West Circular Quay Public Domain Upgrade Works - Major Project 10_0104

Applicant Response to Submissions

5 .Seating

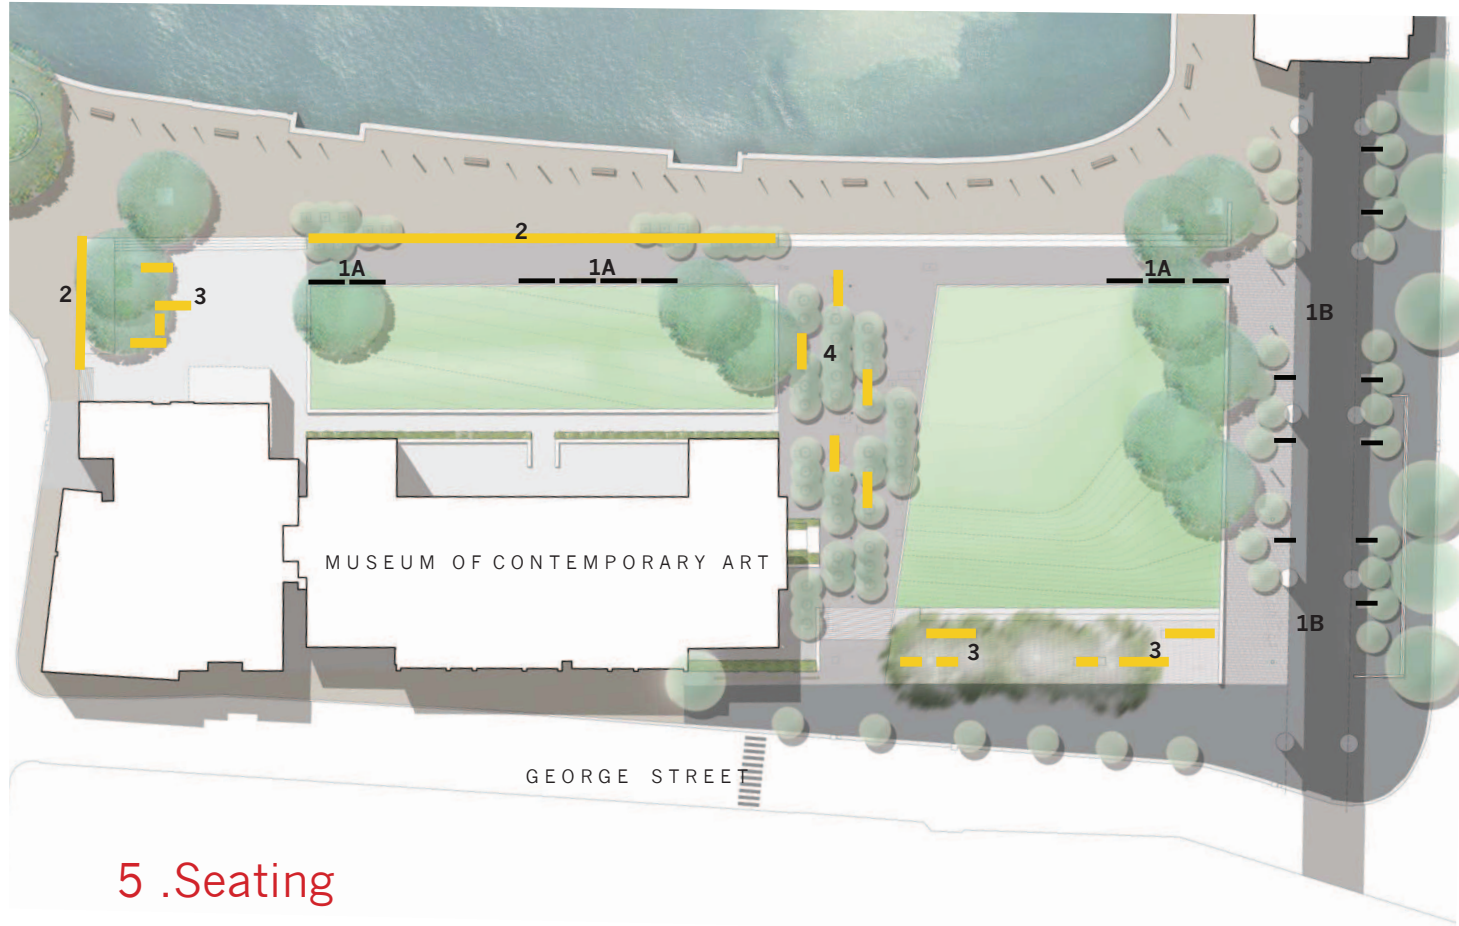
5. Seating:	
a. The finishes on benches may not be appropriate. In particular, the paint finish on concrete benches should be changed to a more robust finish, and the "red gloss paint finish" at "Market Wharf" should be reconsidered.	The only paint finish to concrete benches is to those in the <i>Market Wharf</i>. The paint finish will be suited to a marine environment and treated to withstand high use/vandalism.

b. Inadequate details are provided about the street furniture; in particular, clarification is needed about "standard benches" and whether the concrete benches contained in the documentation are proposed or illustrative precedents only.	Refer to Project Plan 5. <i>Seating</i>, and EA report section 3.2 sub-section 5. <i>Create a generous provision of informal and formal seating.</i> Standard benches refer to the <i>JC Decaux</i> East Circular Quay bench model. Concrete benches in the documentation are used as precedent as Project custom benches are designed.

6 . Paving

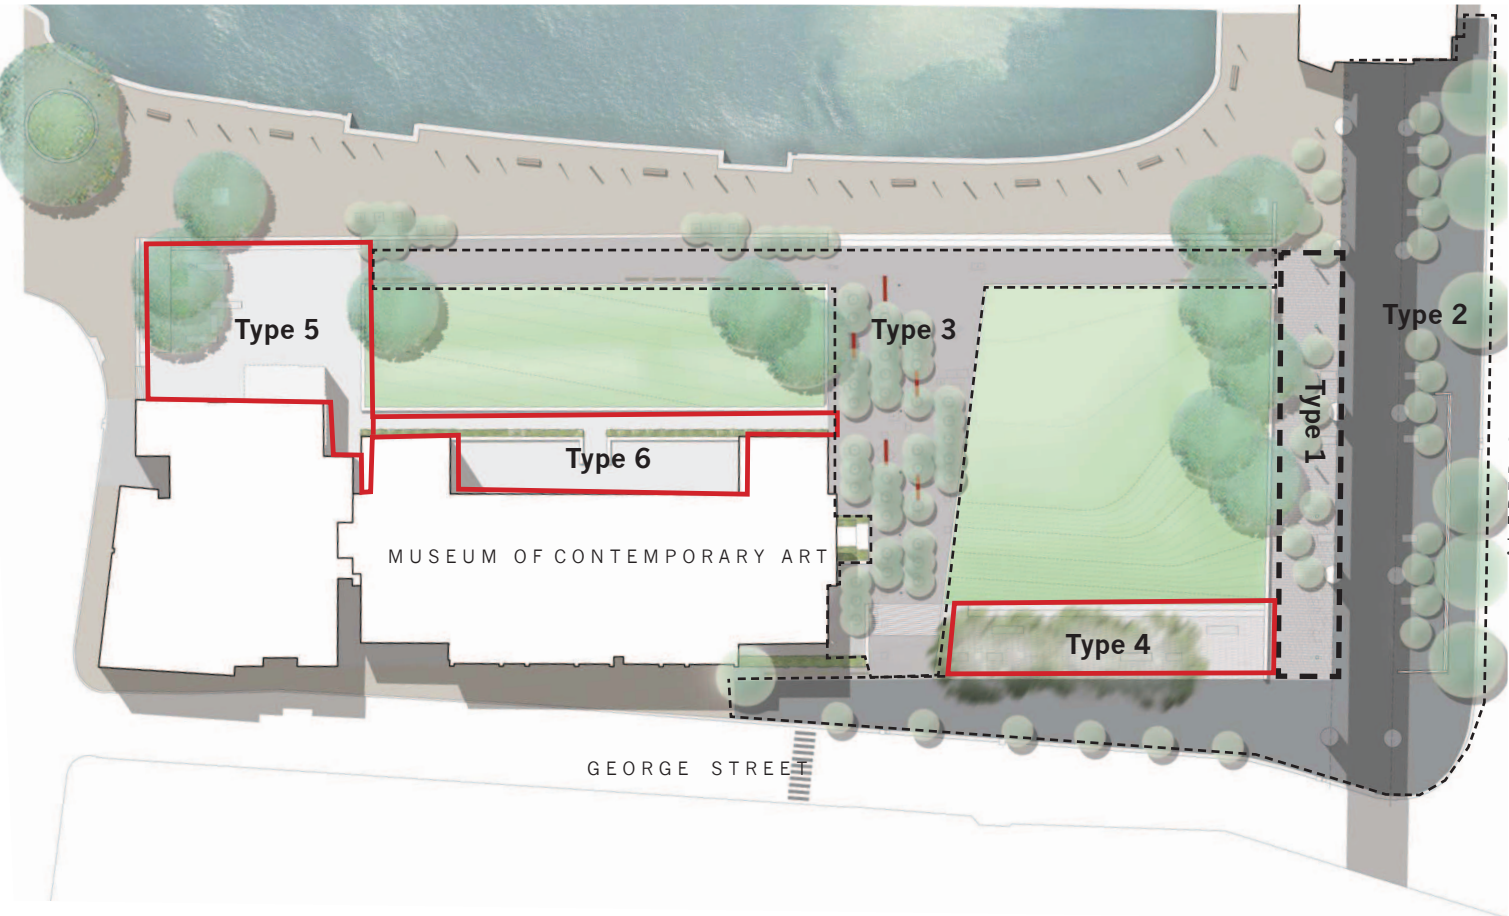
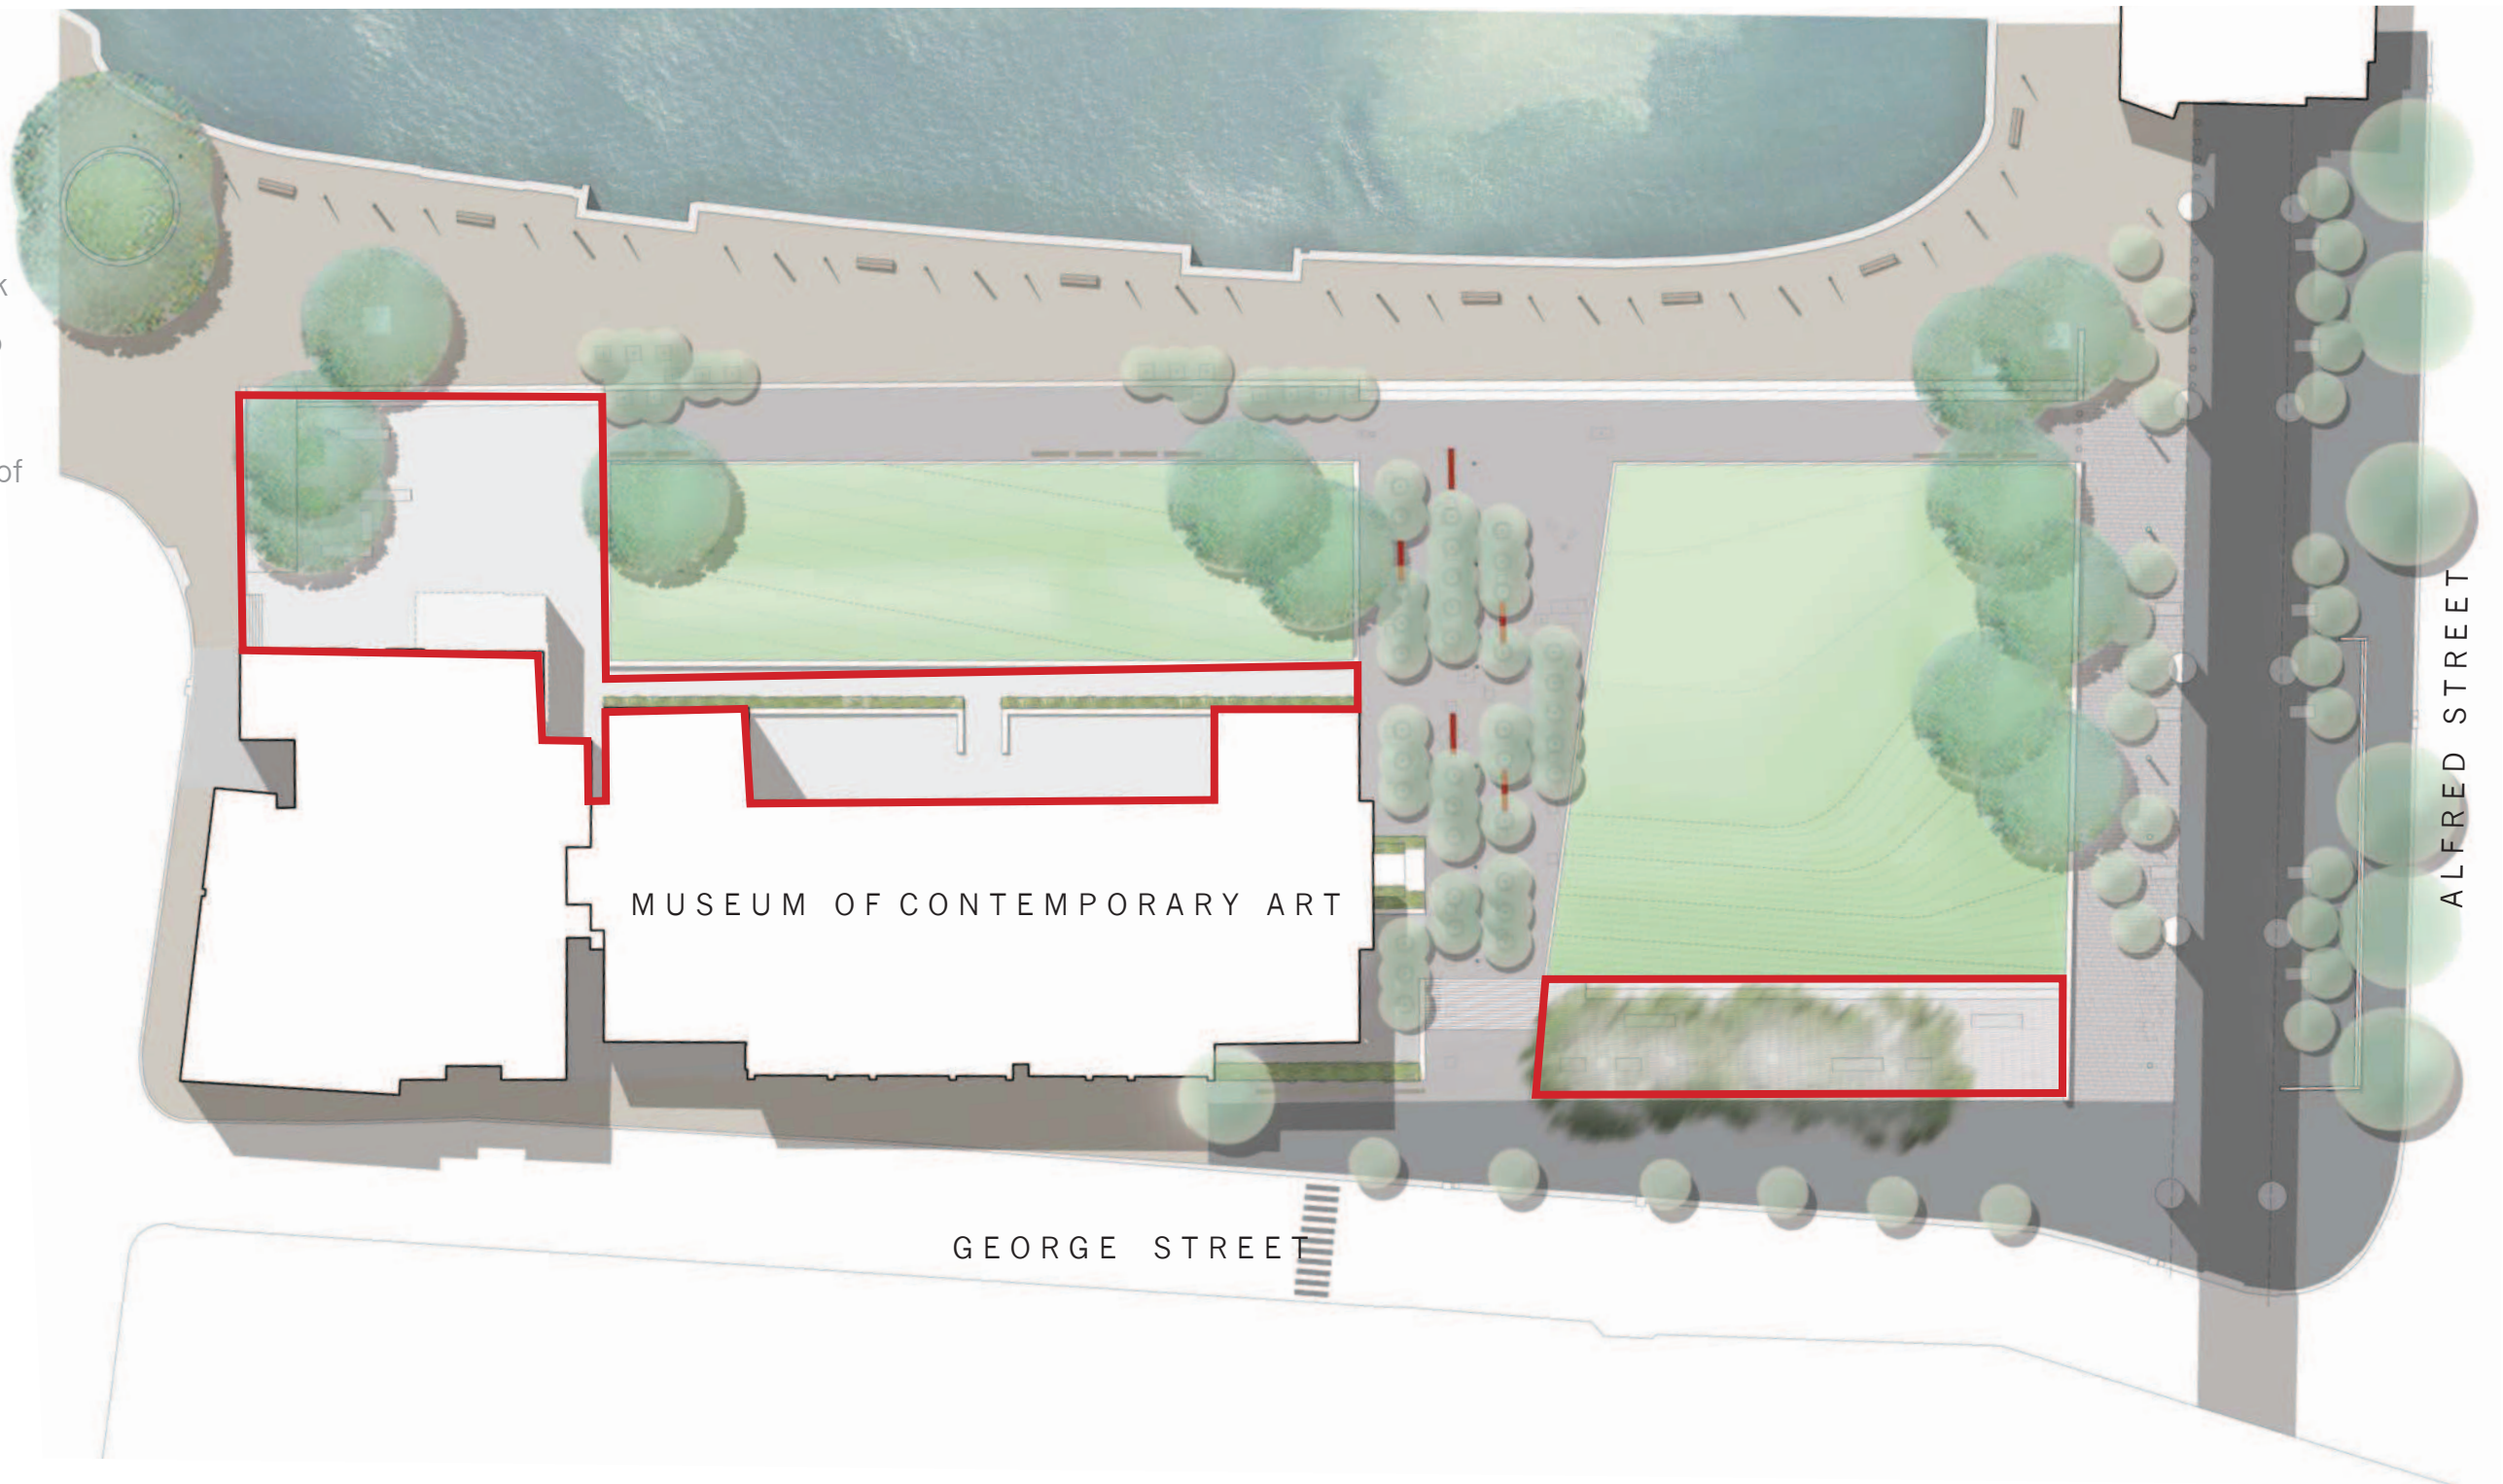
3. Paving: a. The use of eight different paving types in a relatively small area of public domain appears to be excessive and may not create a simplified and unified space.	The design intent for paving is for a simple overall palette of concrete and granite. The paving is integrated and interfaces with a number of existing City of Sydney and The Rocks spaces. Therefore an appropriate number of existing and new paving types are required to a total of 4 materials: - 1. Stone setts and Stone pavers (the same material just different forms) 2. Existing Bricks 3. Concrete precast (MCA raised forecourt and for the lookout); and 4. Asphalt in the heritage interface zones as per The Rocks heritage palette.

Government Agency	Authority
b. The use of asphalt at the George and Alfred Street edges is not acceptable as it is not consistent or integral with the City's paving standards which require granite at this location.	The use of granite along George Street north of the Cahill is not assumed given the desire for clear visual and aesthetic change from the City to The Rocks – asphalt and bricks are The Authority's basic heritage related paving materials. The Alfred St edge is an existing asphalt edge transition between the City and The Rocks. This will be extended and refurbished for a cohesive look, feel and finish to the edge of the park and Alfred and George streets.

c. Insufficient details are provided about the pattern, size and colour of all new paving types and extent of paving works, as well as internal inconsistencies in the documentation with regard to the footpath finishes along Alfred and George Streets.	Details are provided under Plan 6. <i>Paving</i> and to EA report section 3.2 sub-section 2. <i>Create clear and generous links to The Rocks, George and Alfred Streets</i> and sub-section 6. <i>Create a unified and coherent ground plane.</i> The Government Architect Office can provide to the Department, on request, additional detail and clarifications as the design documentation is finalised.
